From: Amanda Scholes on behalf of Planning.Responses
Sent: 27 March 2017 09:30
To: Planning Scanning
Subject: FW: The Gatehouse, Lidsey Road, Ref: AL/9/17/DOC

2nd Drainage Comments.

From: Mark Holman [REDACTED]
Sent: 23 March 2017 18:13
To: Simon Davis
Cc: 'andy.bryant'; michael.ellwood; 'Steve Gill'
Subject: The Gatehouse, Lidsey Road, Ref: AL/9/17/DOC

project	Residential development The Gatehouse. Lidsey Road. Woodgate		
detail	site levels as proposed		
drawn	sgr	checked	
date	09-15	status	Const.
a1 scale	1:50	a3 scale	1:100
	8590	rev	B

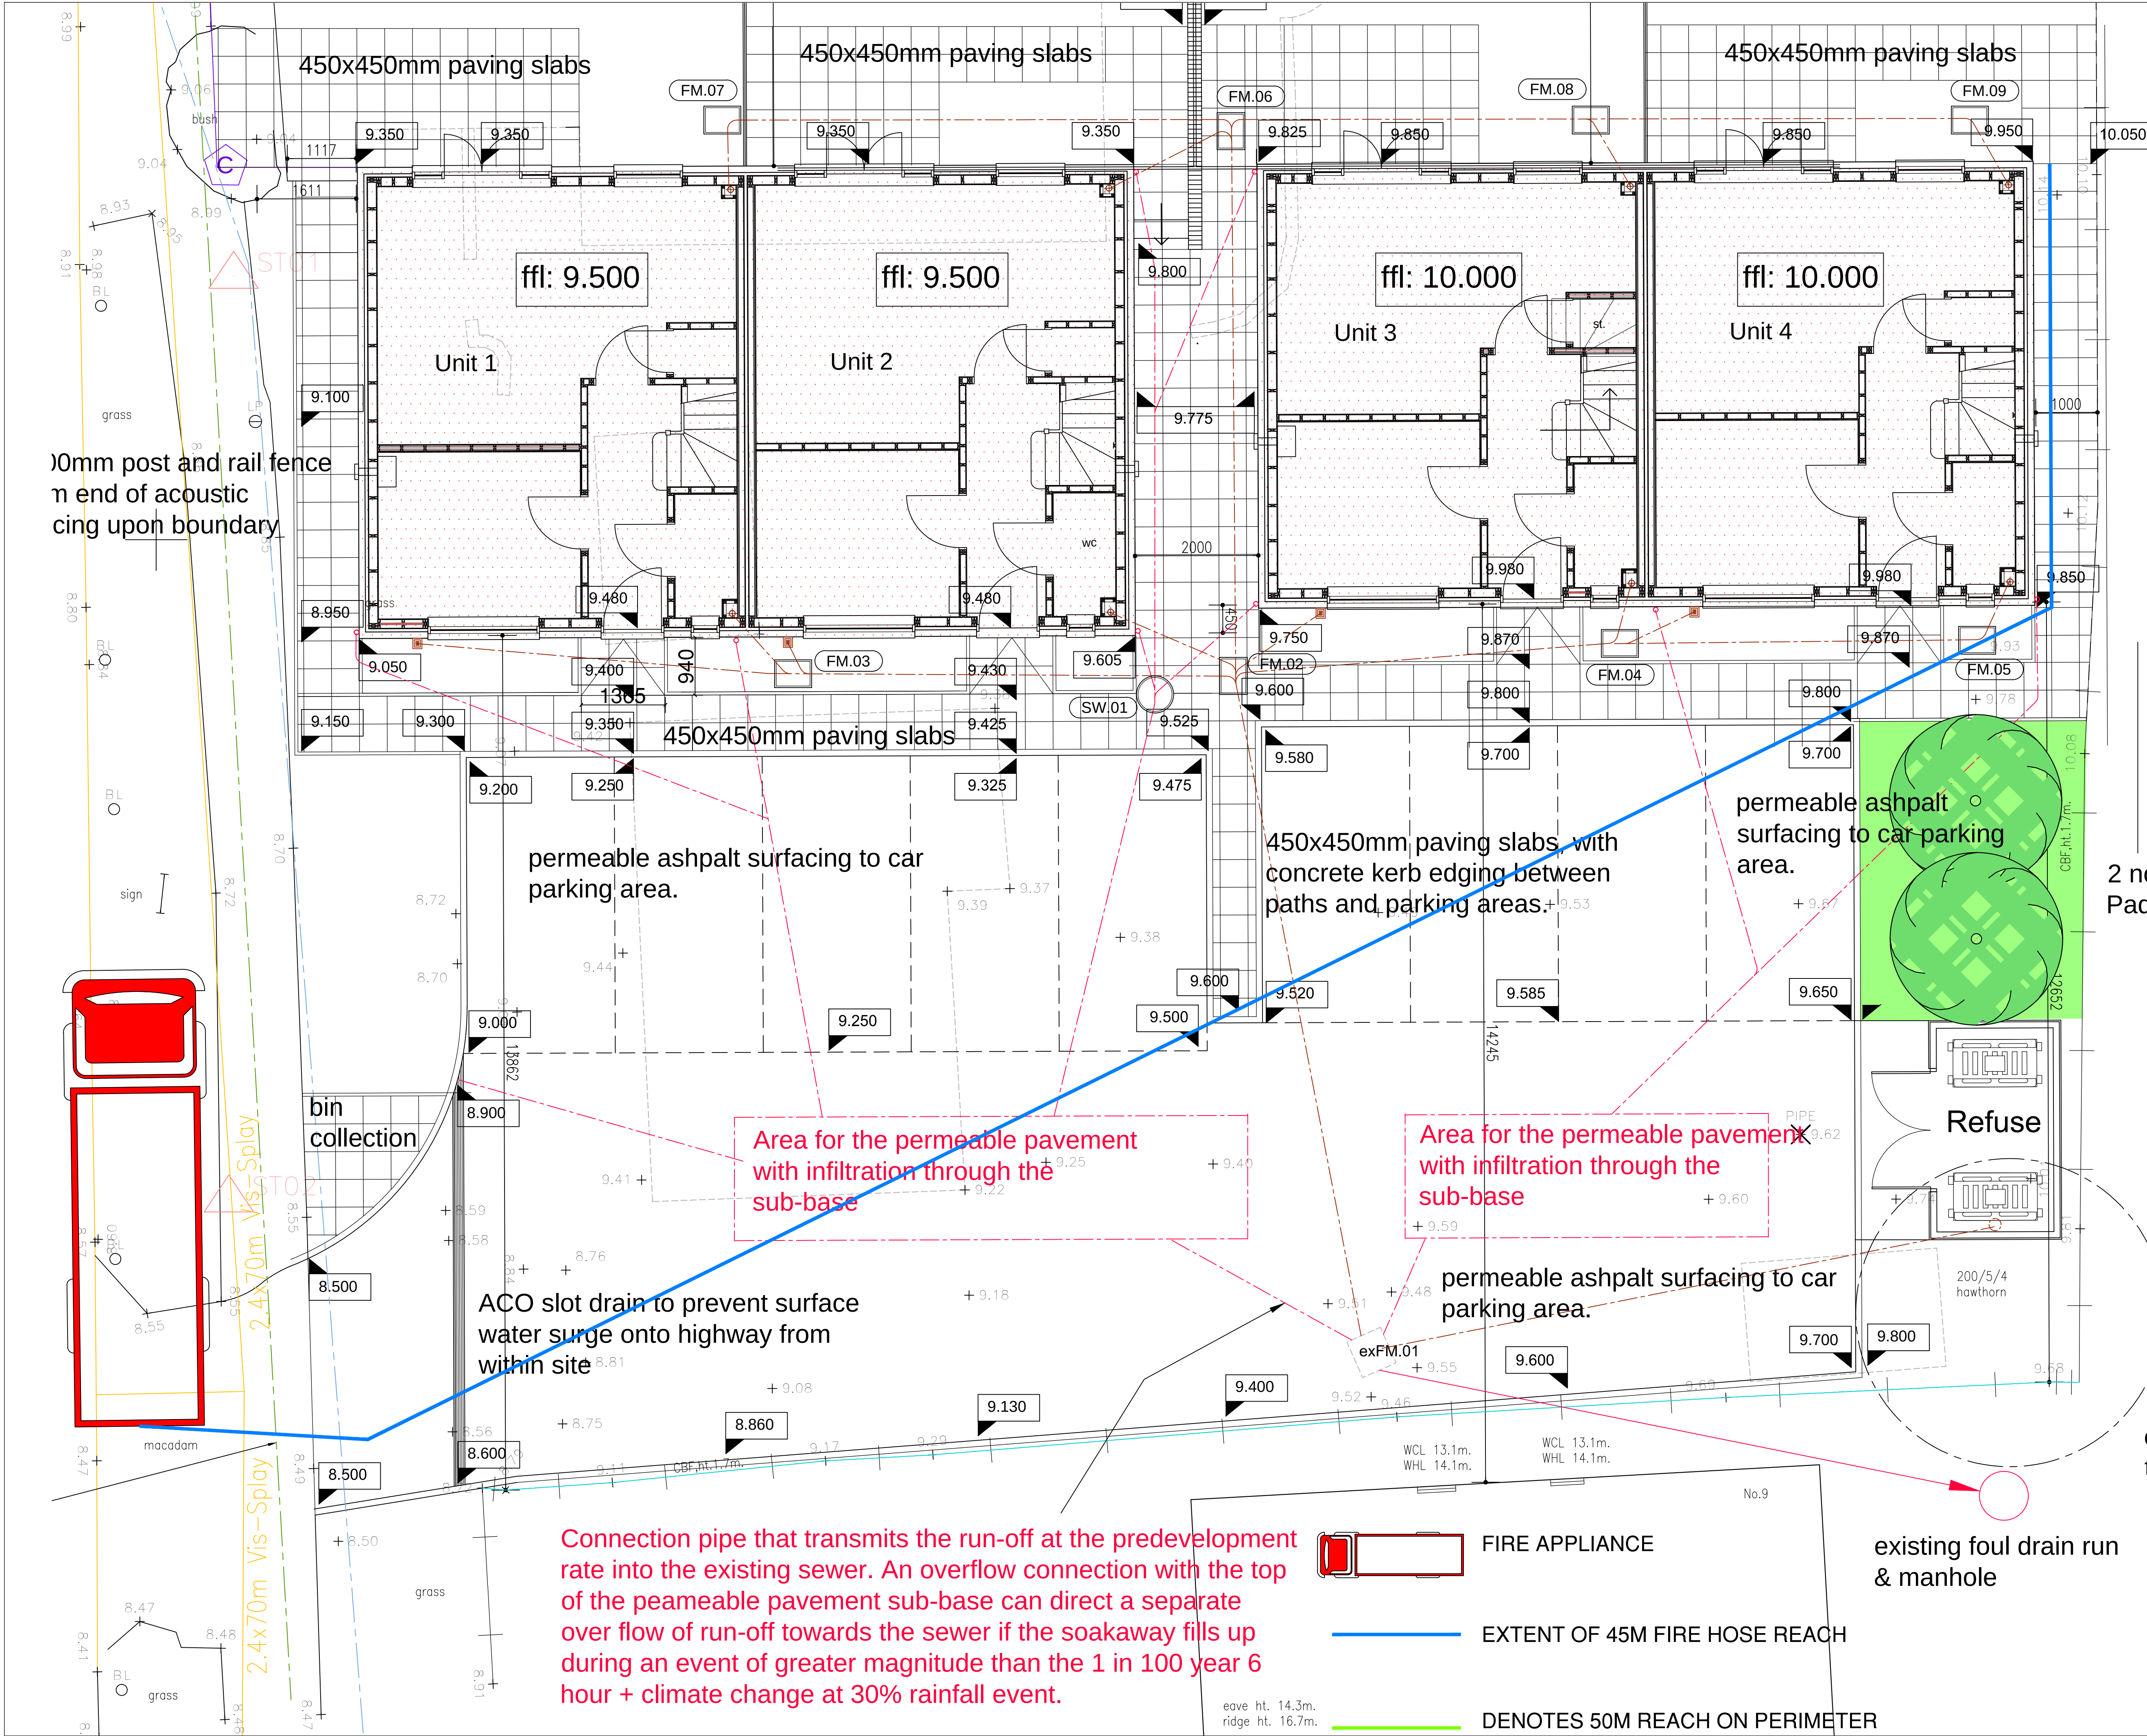
I think I see the problem. We have Drawing 8590-11B on our system which states that:

"Connection pipe that transmits the run-off at the predevelopment rate into the existing sewer. An overflow connection with the top of the permeable pavement sub-base can direct a separate over flow of run-off towards the sewer if the soakaway fills up during an event of greater magnitude than the 1 in 100 year 6 hour + climate change at 30% rainfall event."

I assume then that 8590-10-B should replace 8590-11B? Please confirm.

That is correct, the submitted drawing takes precedence as it is not intended in any way to have the surface water connect into the existing foul system,

project	Residential development The Gatehouse, Lidsey Road. Woodgate		
detail	site layout plan		
drawn	sgr	checked	
date	09-15	status	Const.
a1 scale	1:100	a3 scale	1:200
		8590 10	rev B

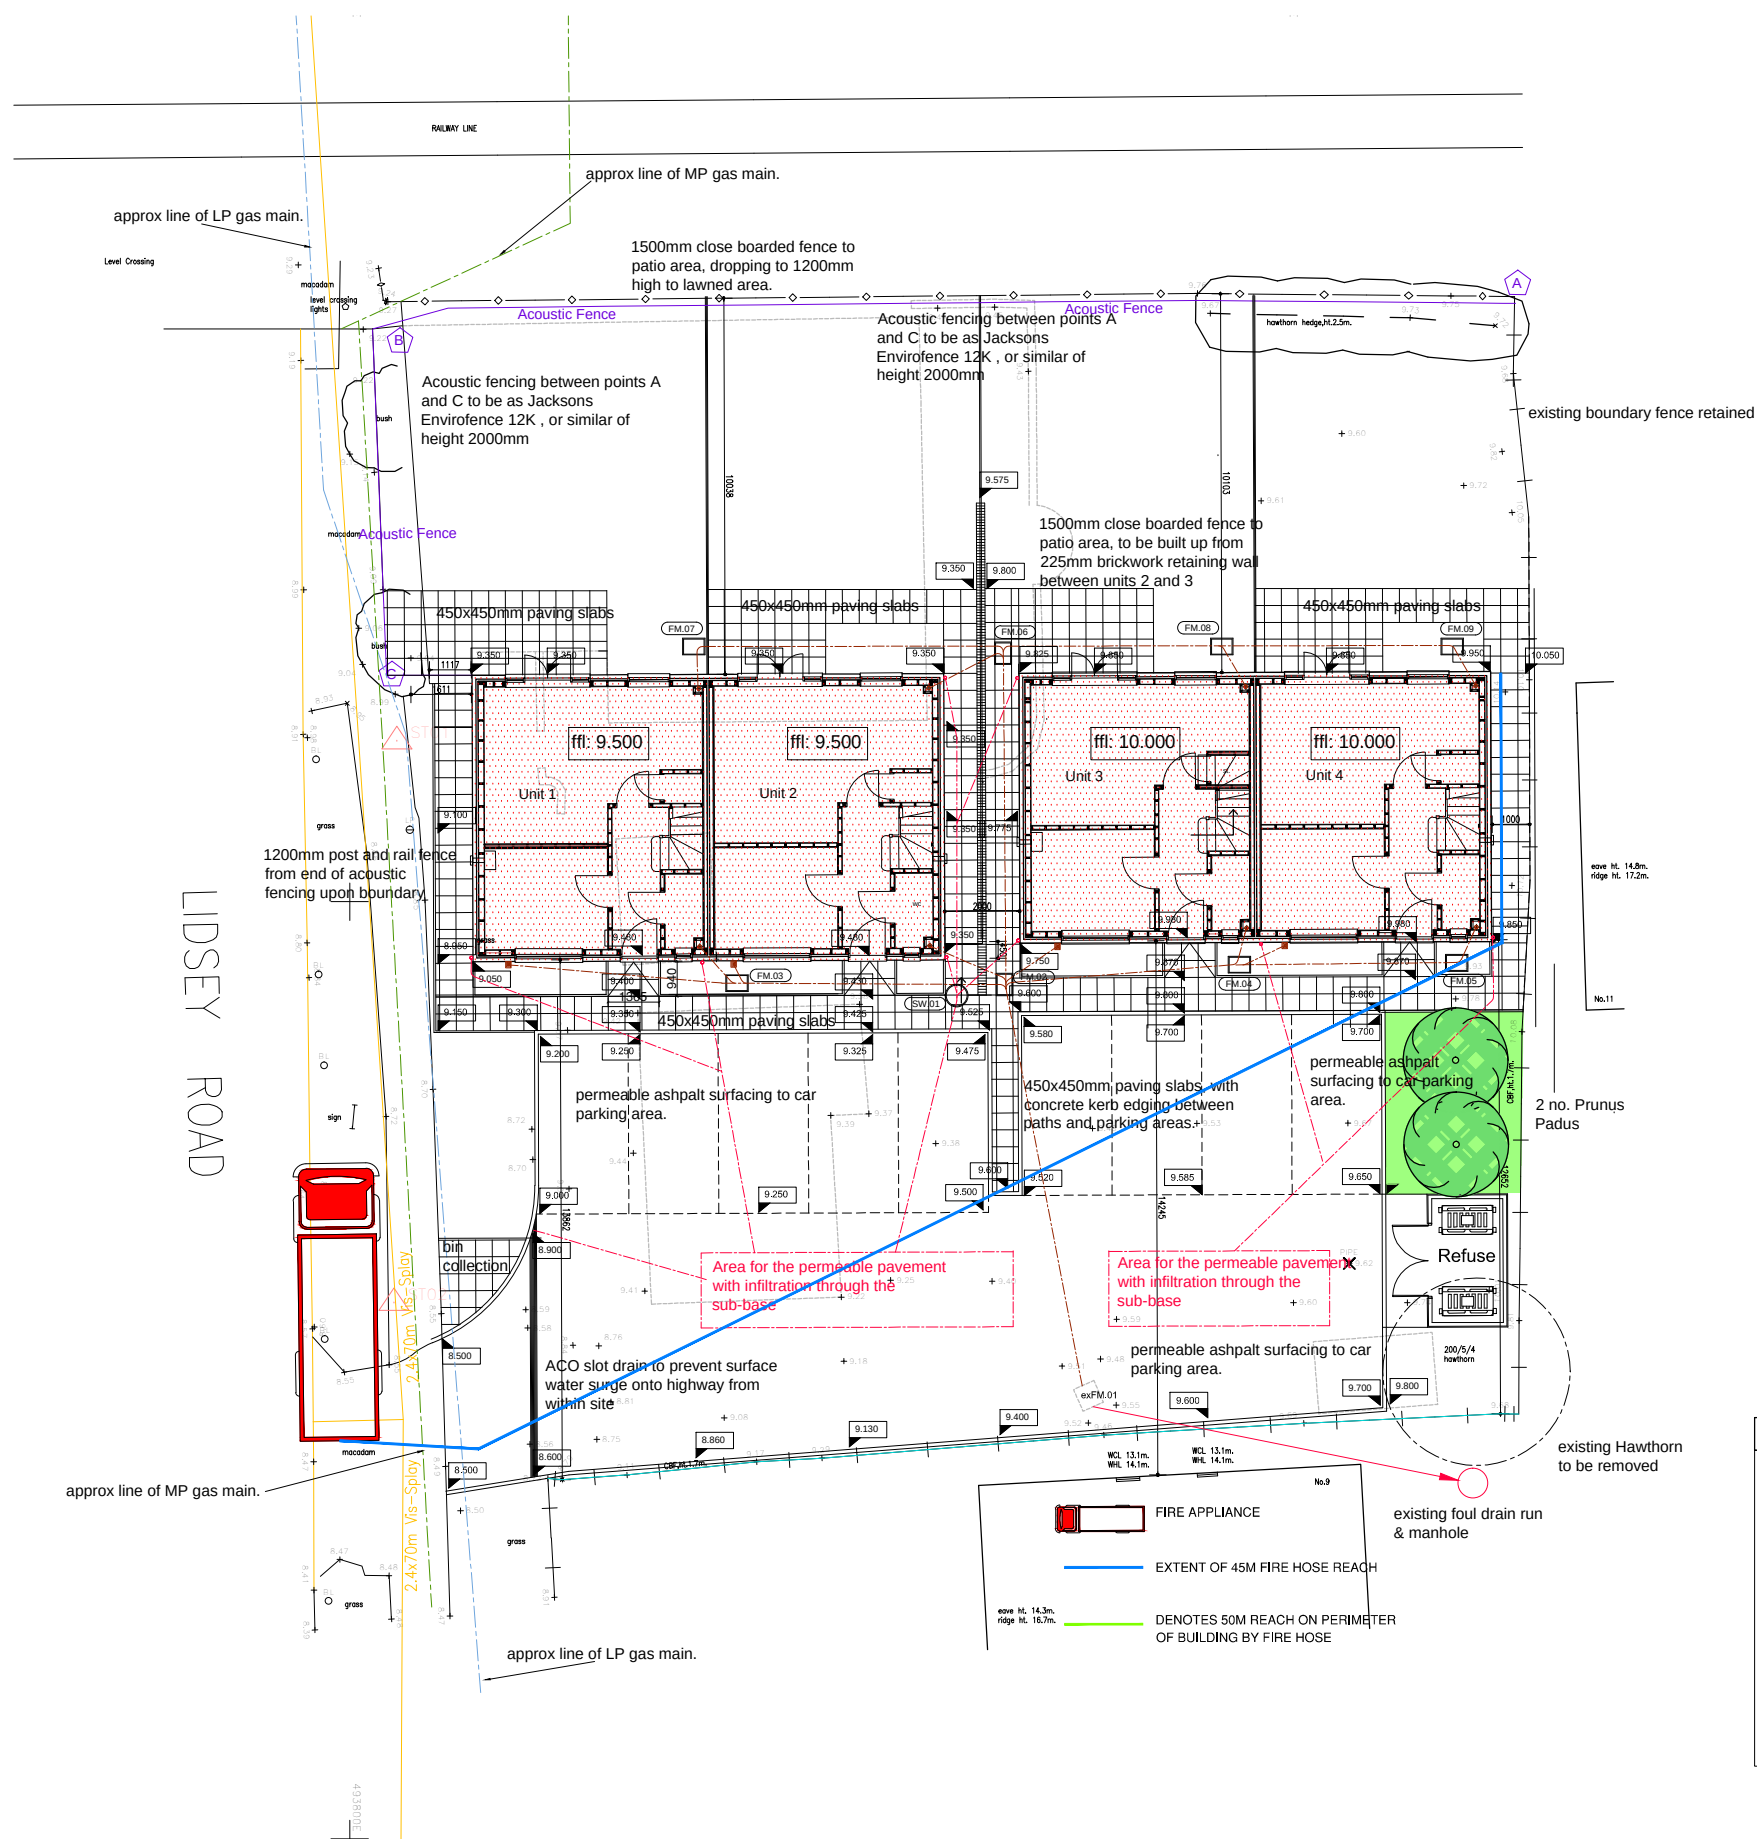
Now that it is confirmed that there will be no connection to the foul drain, I find the proposals acceptable.

Condition 9 – We attach our drawing number 8590-10B, which had previously been issued, this showing the amendment of the SW to not discharge into the foul drain, so we are somewhat surprised this has not been discharged. It is not the intention to discharge any SW into the foul and the drawing confirms this so we hope this can be discharged immediately.
